DRB Application No.: 04DRB 01420 (PLF) Project # 1003466  
Project Name: EL CAMBIO PLAZA ADDN  
Agent: CARTESIAN SURVEYS INC Phone No.: 896-3050

**CITY OF ALBUQUERQUE  
PLANNING DEPARTMENT  
9/22/04 DRB  
Comments**

**RE: Tracts A & B, El Cambio Plaza Subdivision/minor plat**

**DEVELOPMENT REVIEW BOARD--SPEED MEMO**

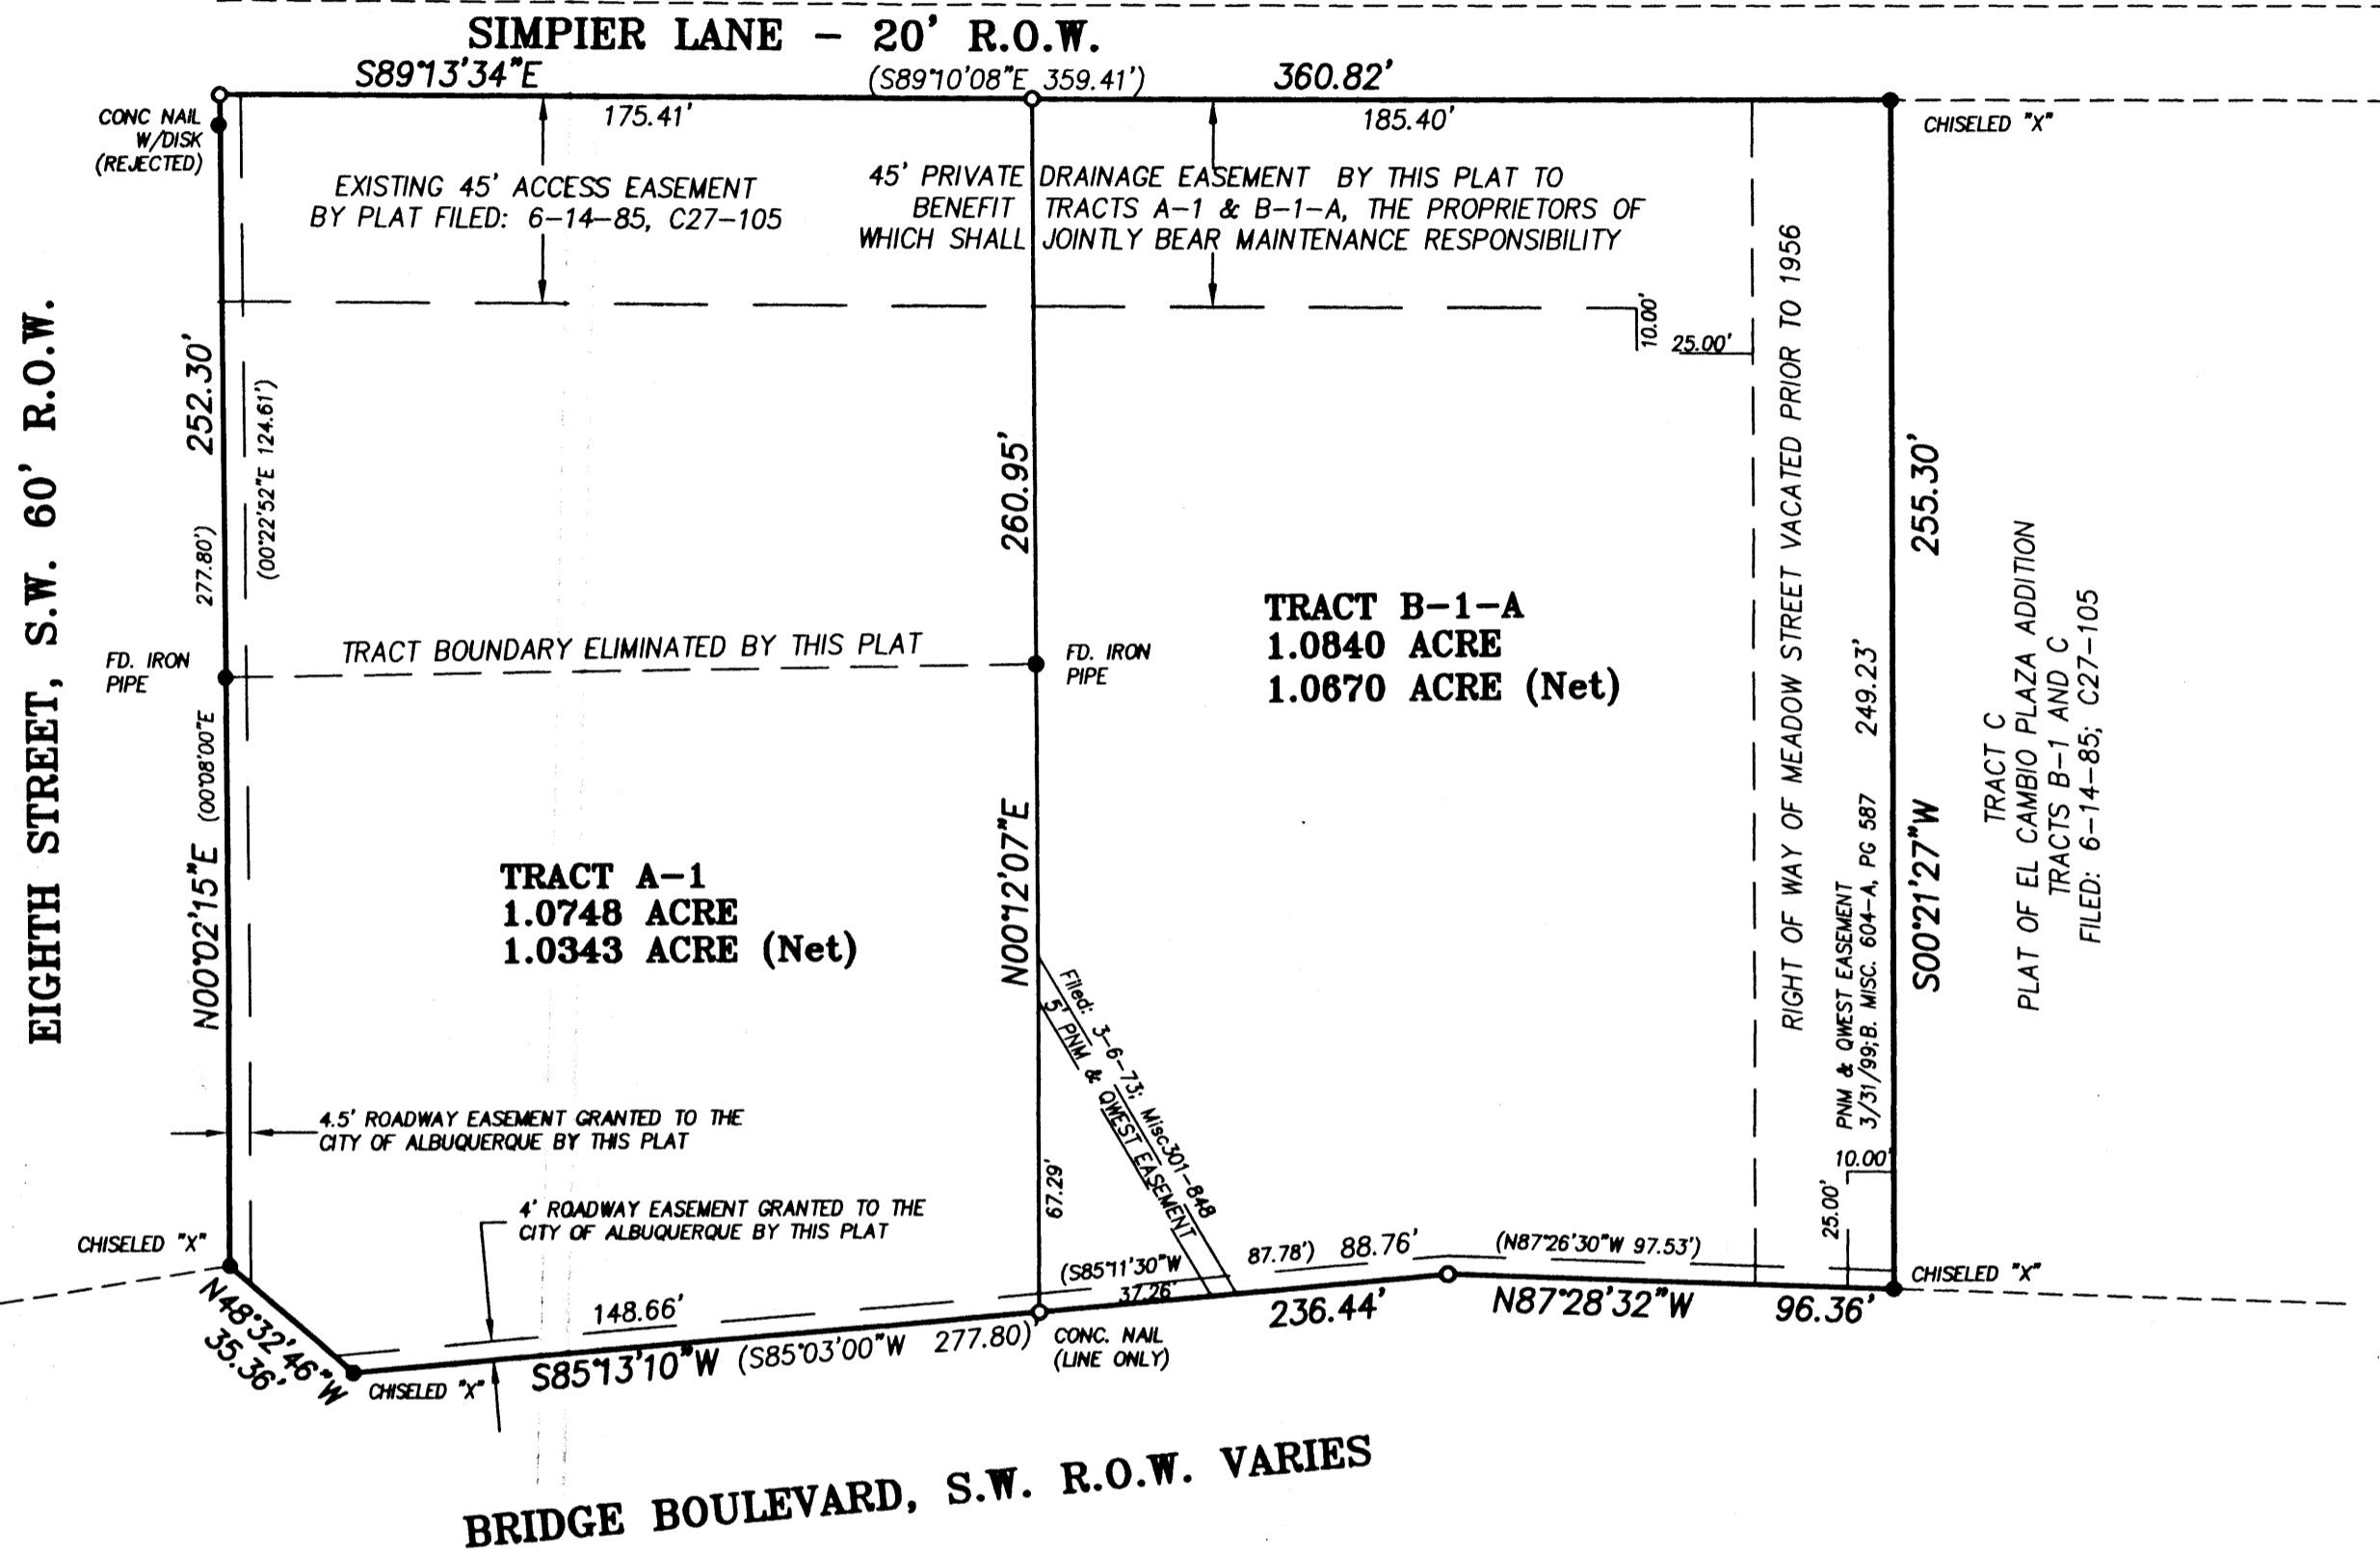
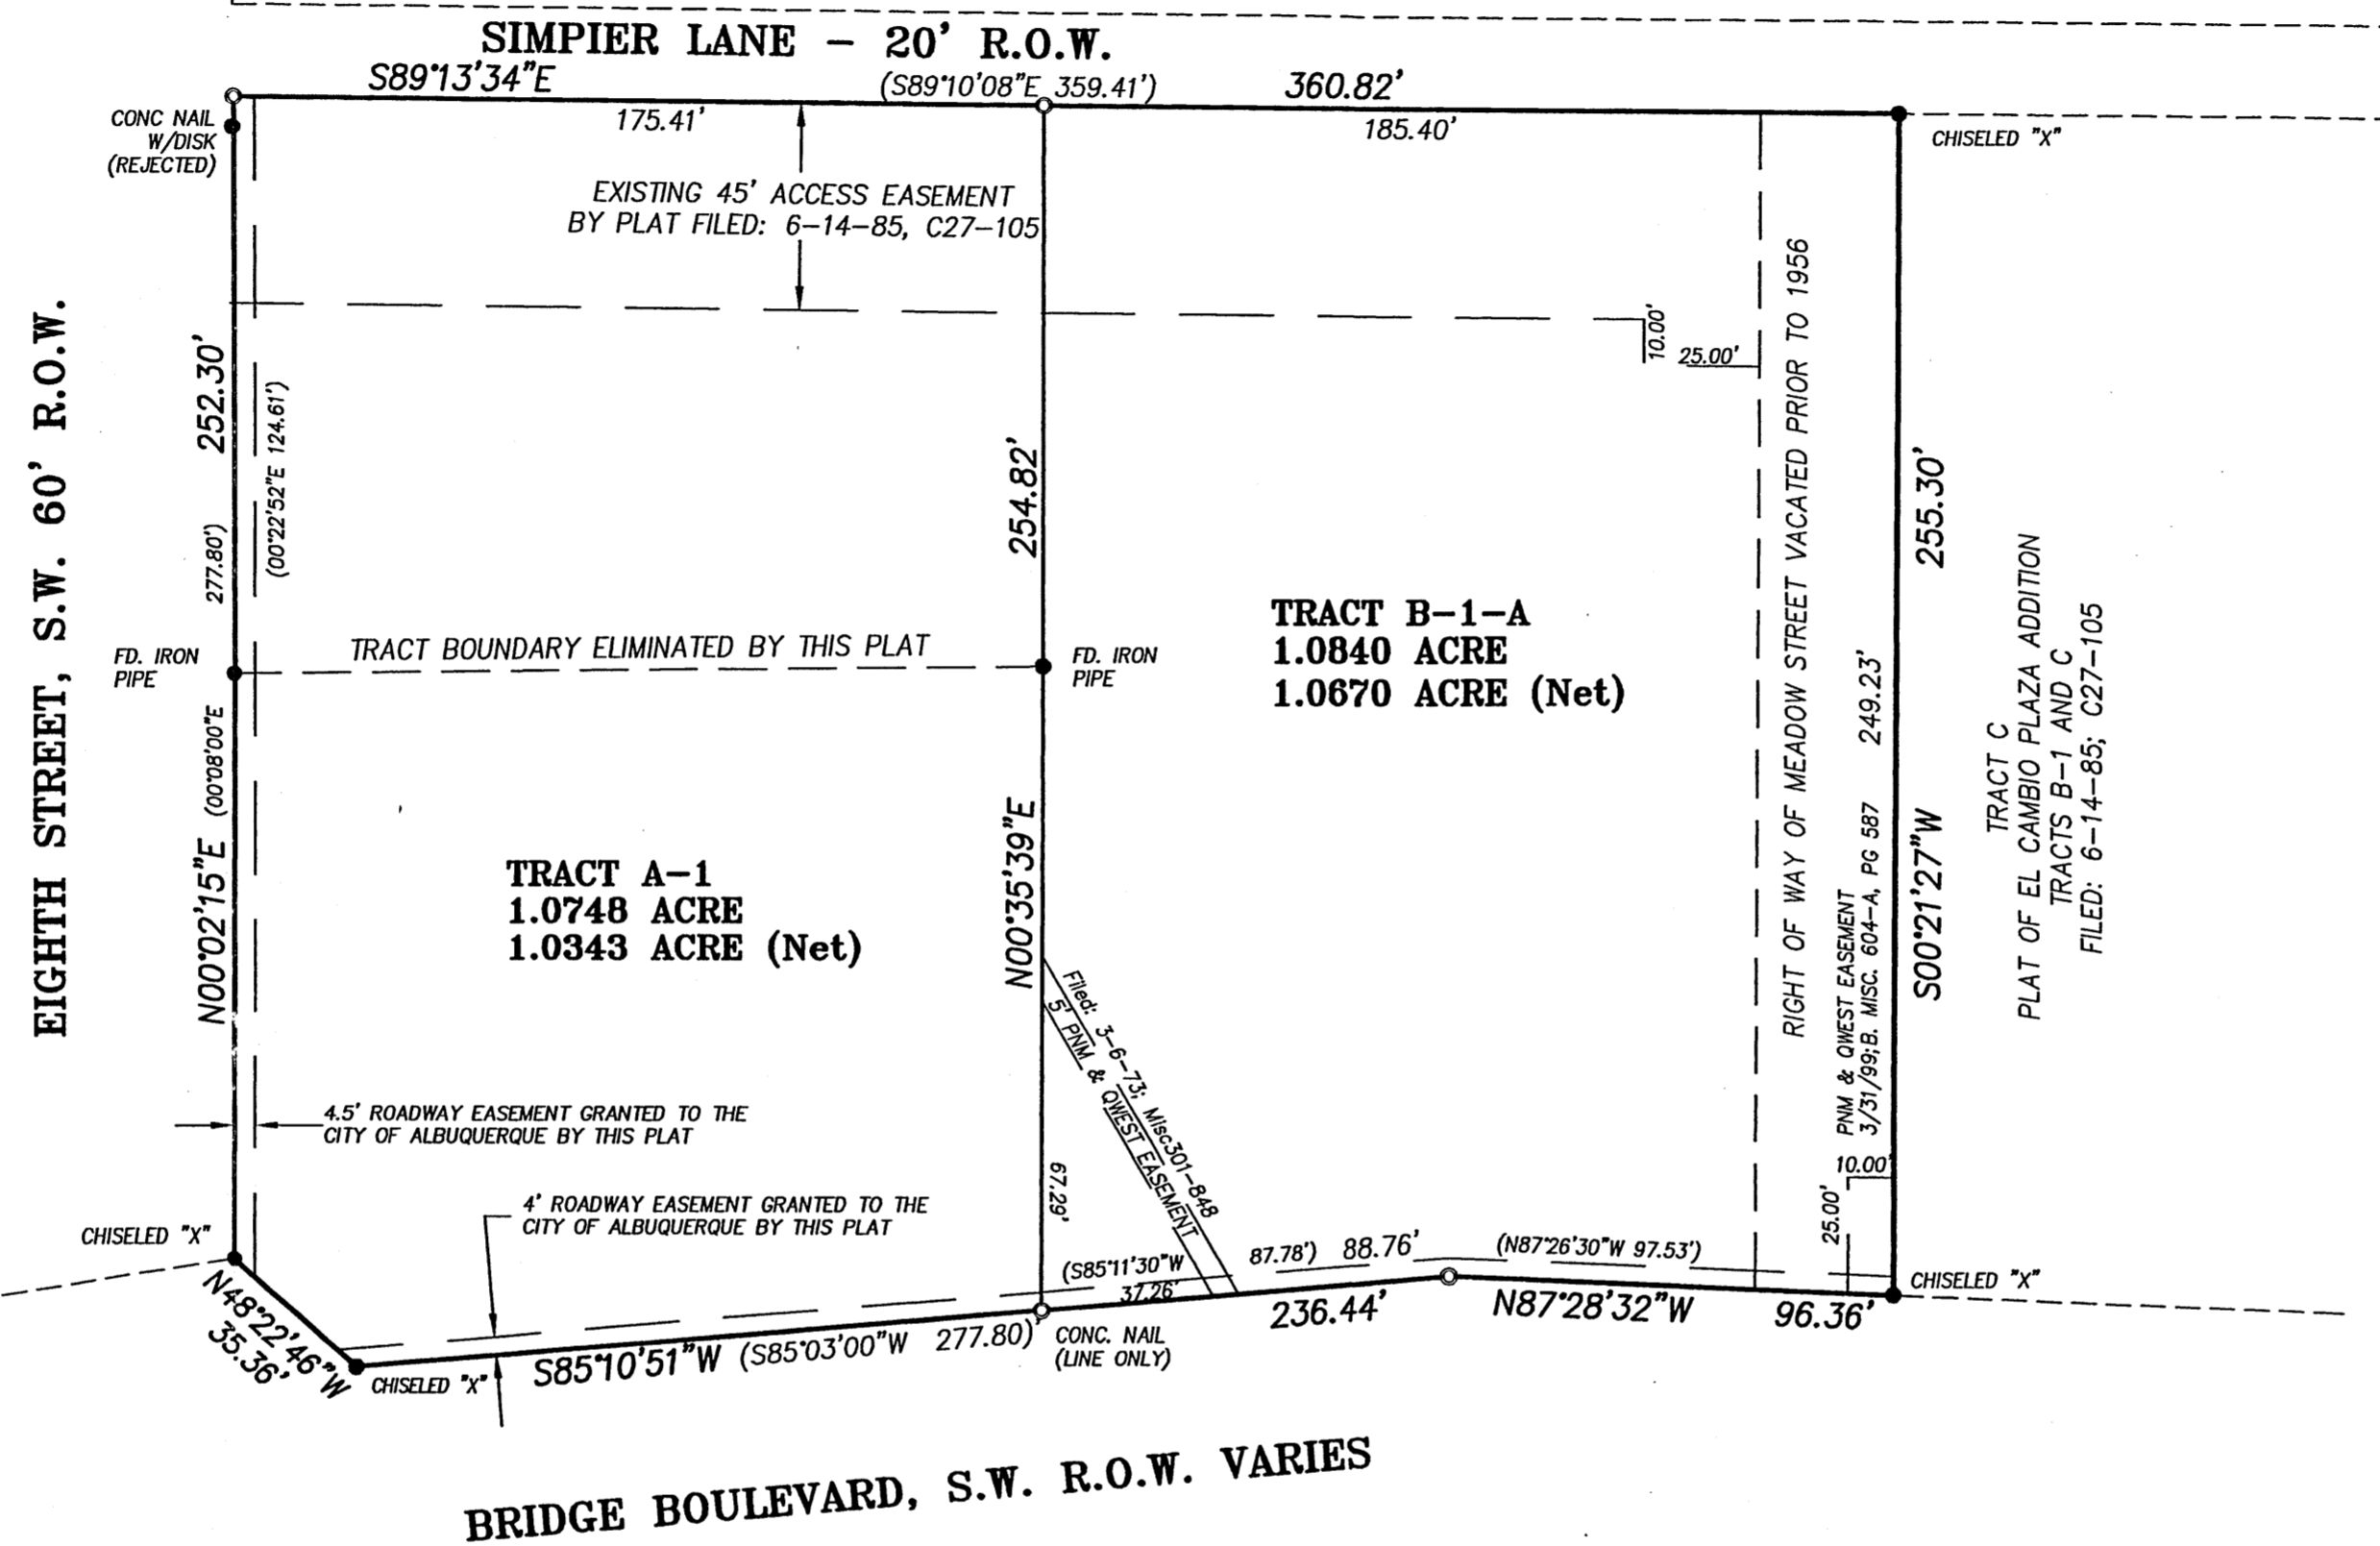
Cross-lot drainage easement may be needed.

1. TRACT B-1 is called out as vacant; AGIS photography c. 2002 shows existing structure w/ parking + landscaping.
2. Where are service lines for B-1? Need easements if any across proposed Tract A-1.
